Application No: EP/163/21/HH
Site Address: 4 Selhurst Close East Preston BN16 2SR
Description of works: Single storey front extension, conversion of integral garage and new detached garage.

Thank you for your internet representation made on 11th January 2022 which has been recorded as an objection with the comments as follows:

Drawing Name
Garage - Proposed

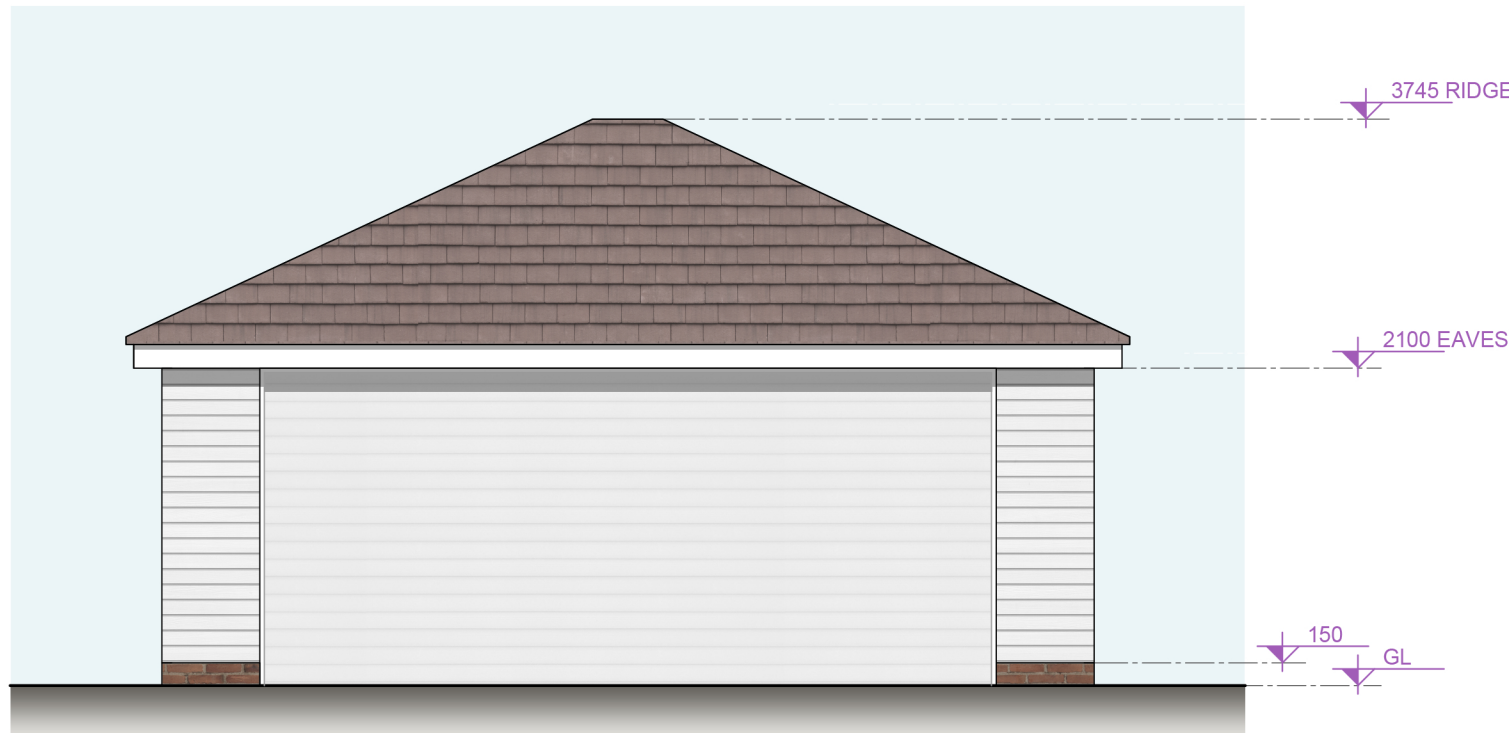
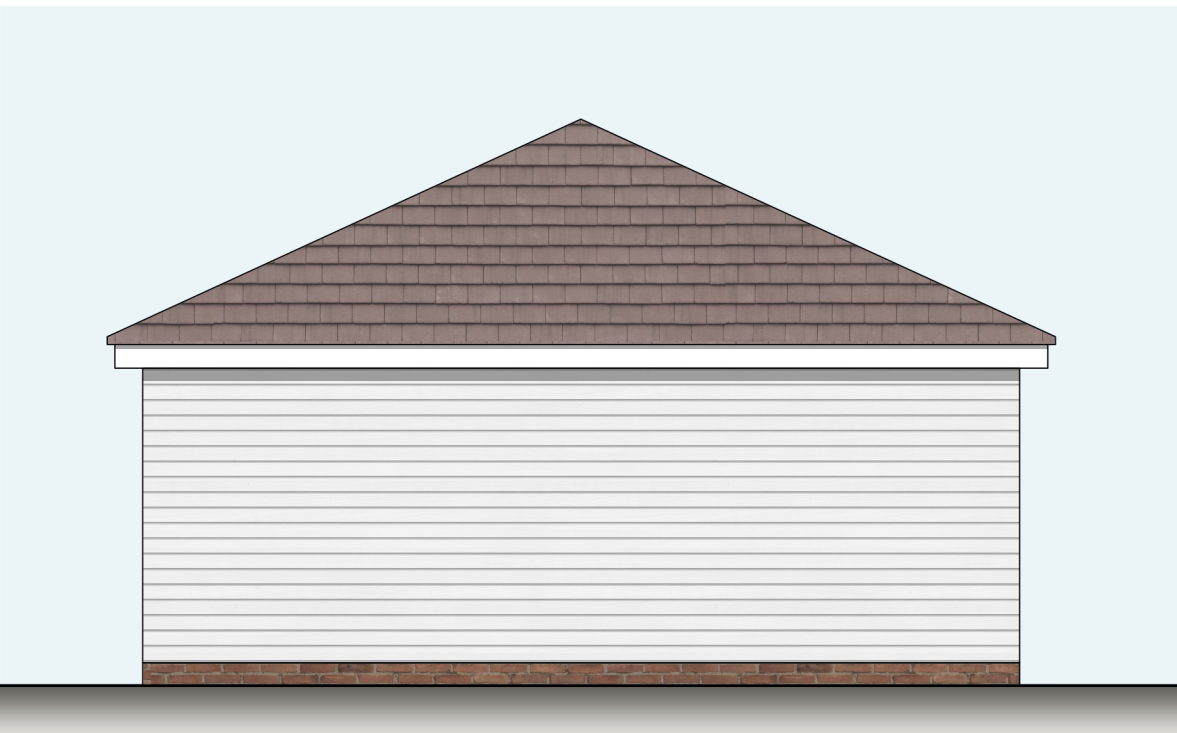
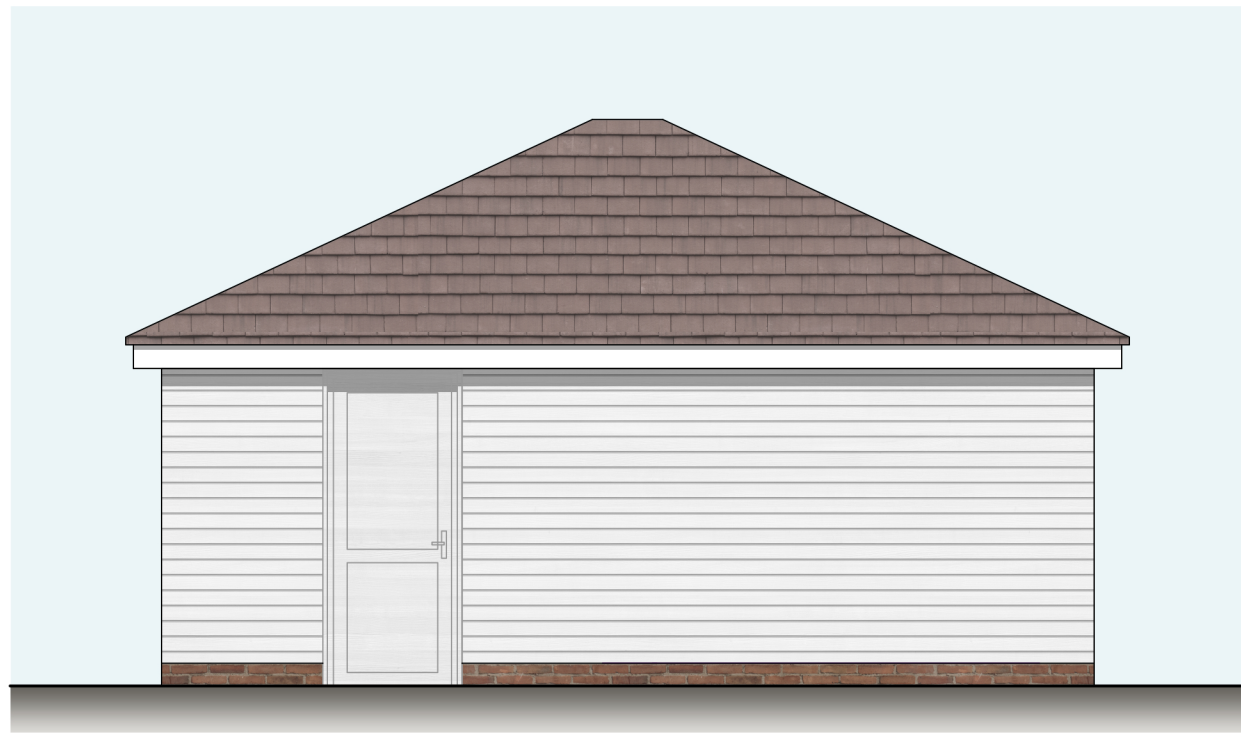
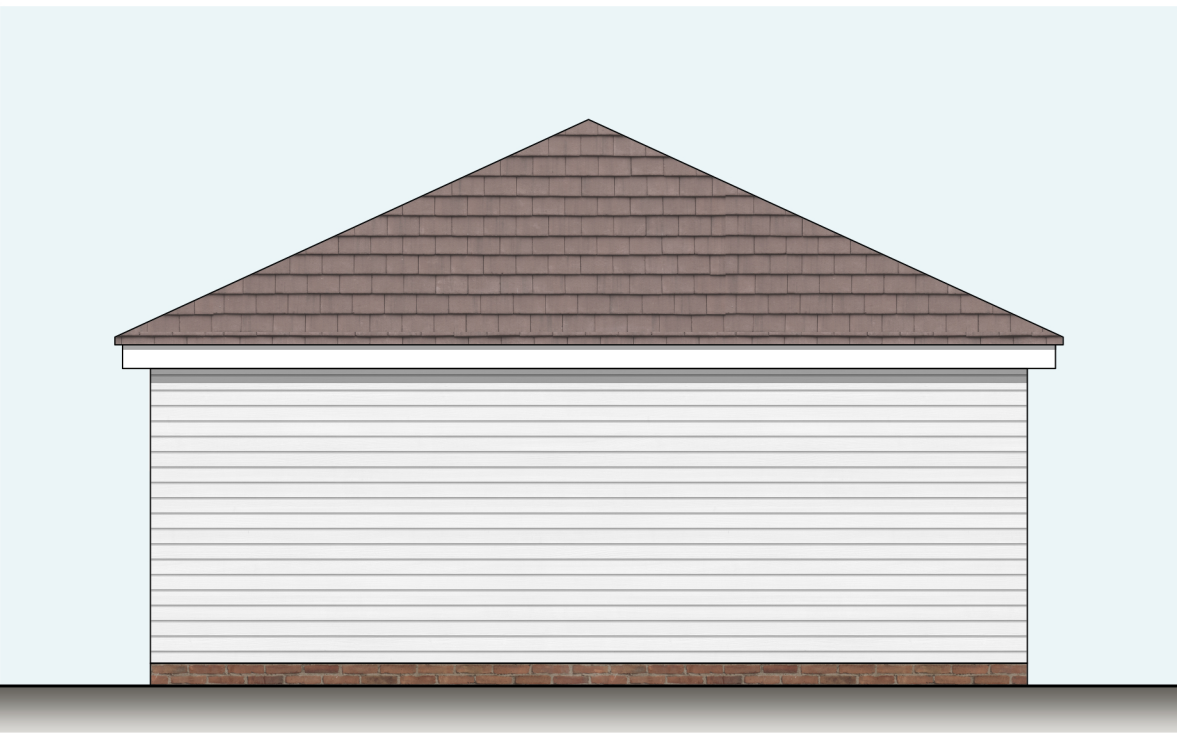
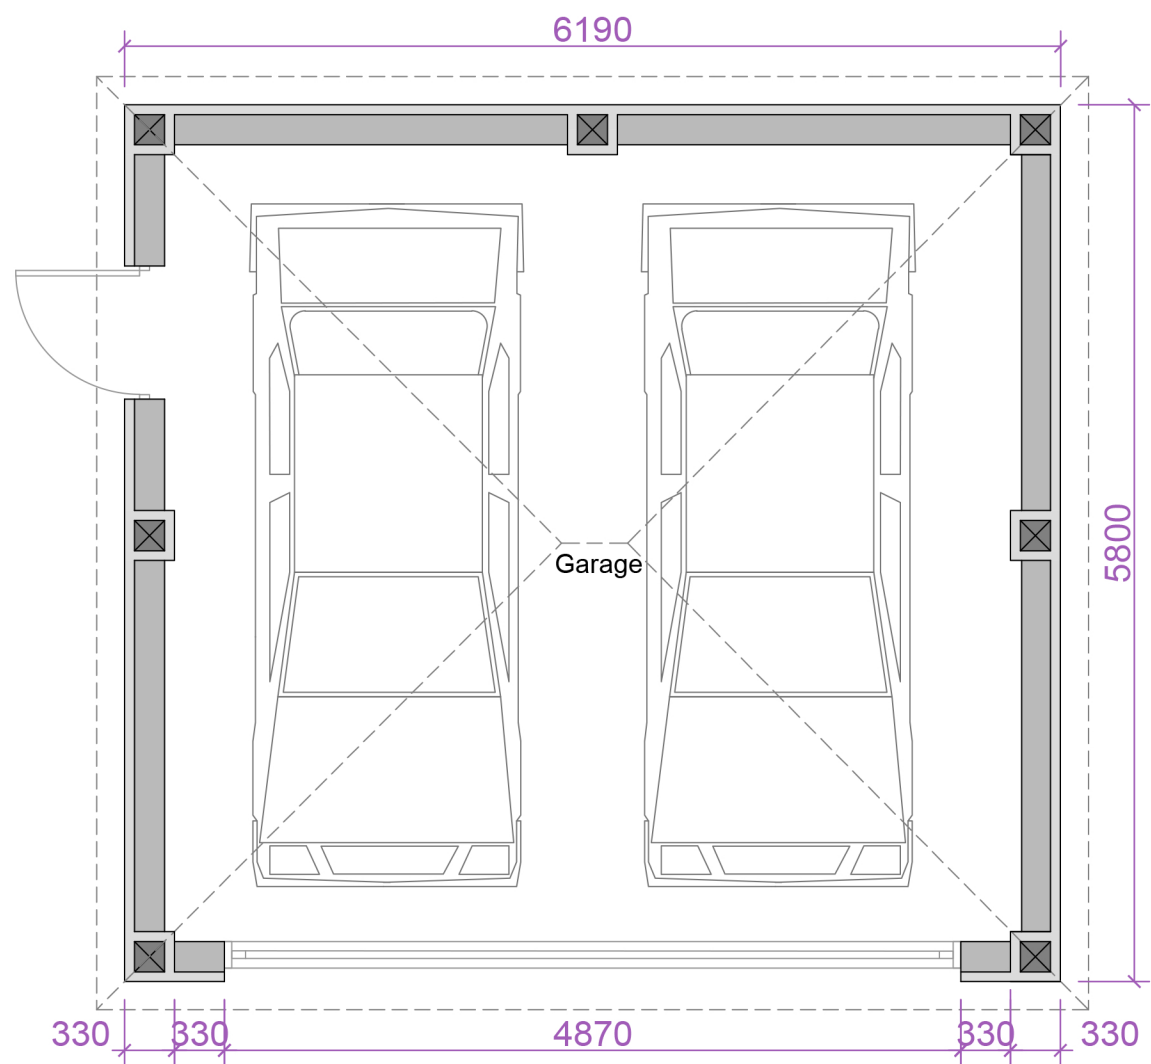
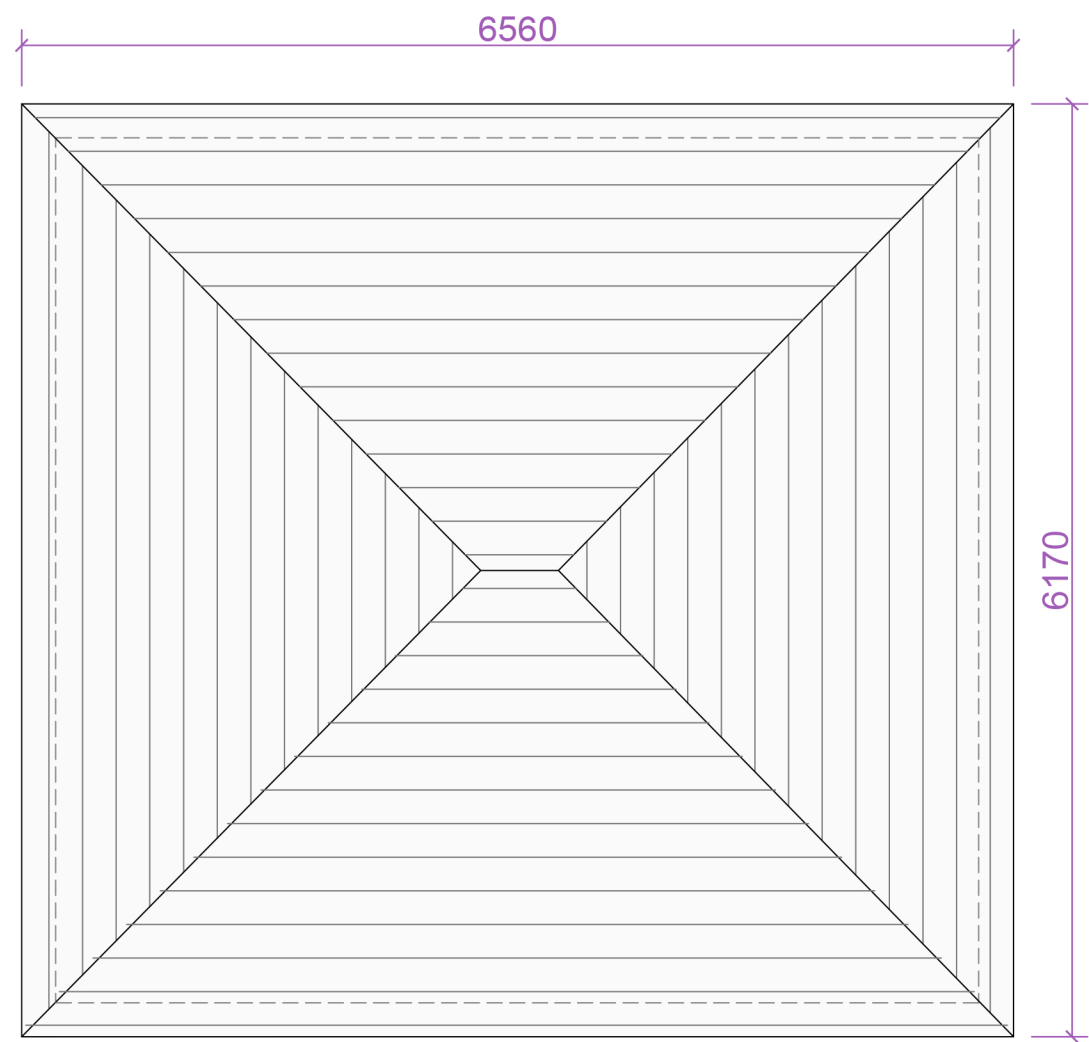
The committee agreed it would object to this Application which it feels would further alienate this property from neighbouring properties because of the proximity to the boundary and height of the proposed garage, the ridge height of which was shown as 3.745m. This structure could be seen as contrary to Policy 2 of the East Preston Neighbourhood Plan.
